September 3, 2025

Kittitas County Community Development Services  
411 N. Ruby Street; Suite 2  
Ellensburg, WA 98926

RE: ACU-25-000002, Boys and Girls Club  
SR 903 milepost 3.45 Rt.

SEPTIC SITE PLAN

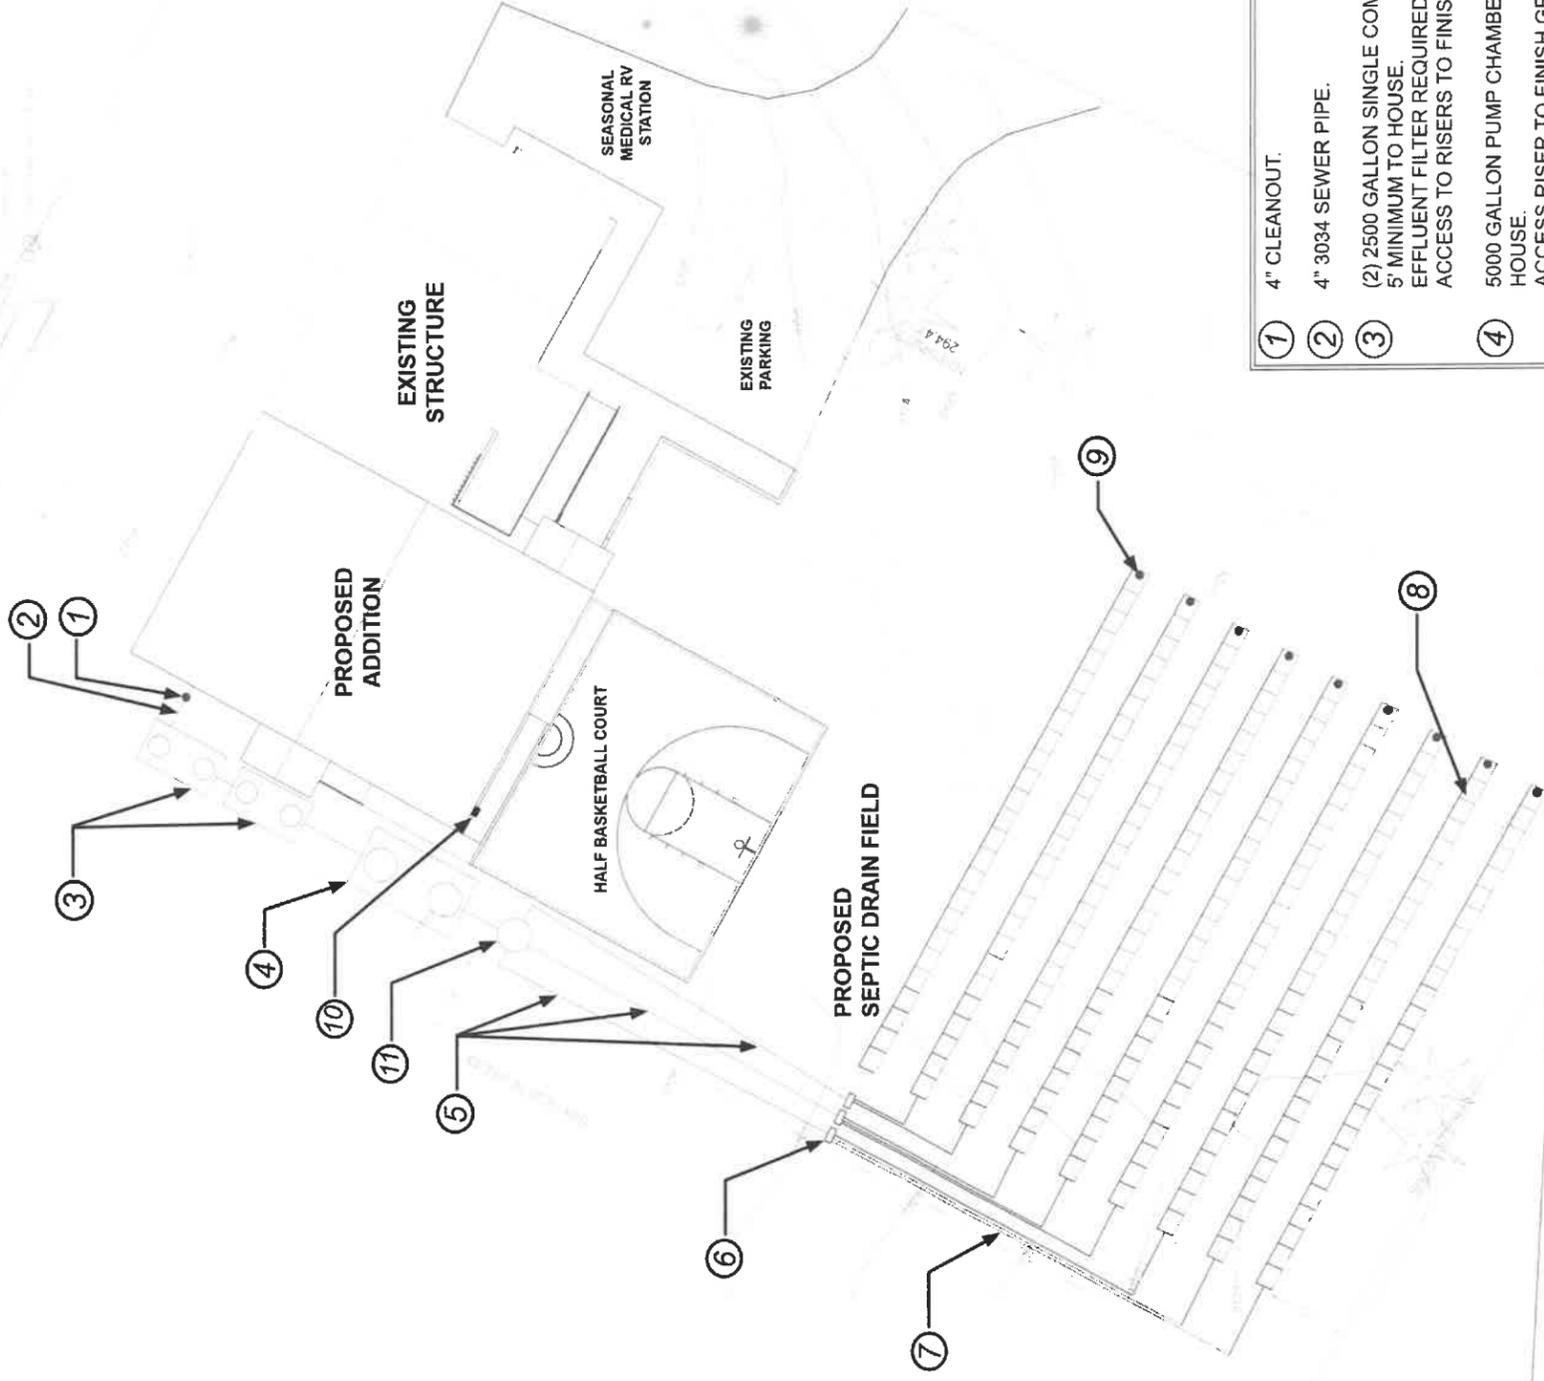
- The subject property is adjacent to State Route 903 (SR 903), a Managed Access Class 4 highway with a posted speed limit of 45 miles per hour. Access to the property is available via the existing Cle Elum Roslyn School District approach at milepost 3.92 left. The driveway located at milepost 3.94 left was closed prior to the construction of the pedestrian pathway in 2015 and subsequently reopened without WSDOT approval. This driveway does not meet minimum spacing or design standards for Class 4 highways and shall be removed. The property owner must coordinate removal with the Cle Elum Maintenance Supervisor Jerry Mus, he can be reached at (509) 674-4443.

- Any proposed lighting must be directed down towards the site and away from SR 903.
- Any snow accumulated on the property shall not be moved onto WSDOT right-of-way. We encourage the proponent to not underestimate the potential for large volumes of snow and designate a snow storage area on the property.
